Appeal Decision

Appeal Ref: APP/R5510/D/20/3259240

15 Sharps Lane, Ruislip, HA4 7JG

- The appeal is made under section 78 of the Town and Country Planning Act 1990 against a refusal to grant planning permission.
- The appeal is made by Mr and Mrs Mackay against the decision of the Council of the London Borough of Hillingdon.
- The application Ref 23160/APP/2020/2106, dated 8 July 2020, was refused by notice dated 27 August 2020.
- The development proposed is alterations to main roof for loft conversion.

REAR ELEVATION

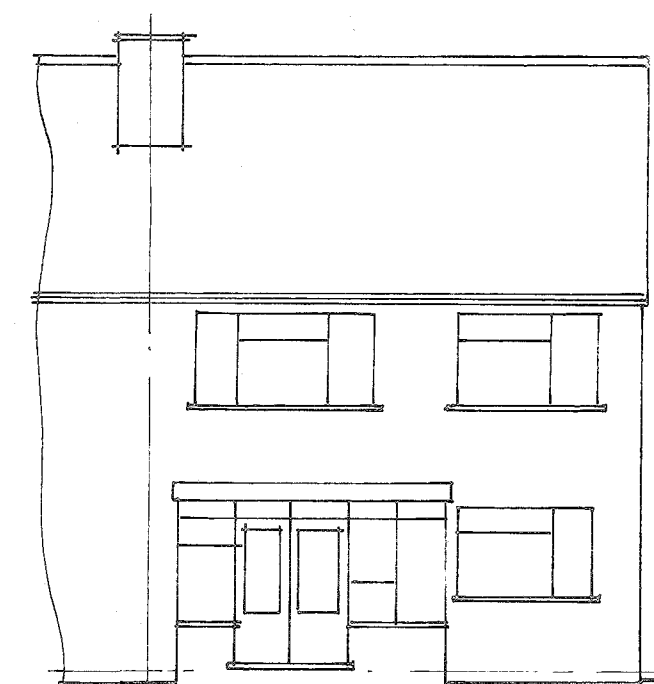
8. A box dormer to the rear roof slope is proposed. The appellants state that the proposed dormer has taken into consideration the issues raised in respect of a previously refused proposal.¹ Whether or not this is the case, the proposed dormer the subject of this appeal would appear as a rather large and bulky addition to the rear roof slope. As such, it would draw attention to itself as an alien feature, largely out of keeping with the roofscape of the immediate area.

9. Further, as a result of its size and positioning, the proposal would not appear as a subordinate addition to the host property, but would appear as dominant feature on the roof slope, drawing attention to itself as a prominent addition.
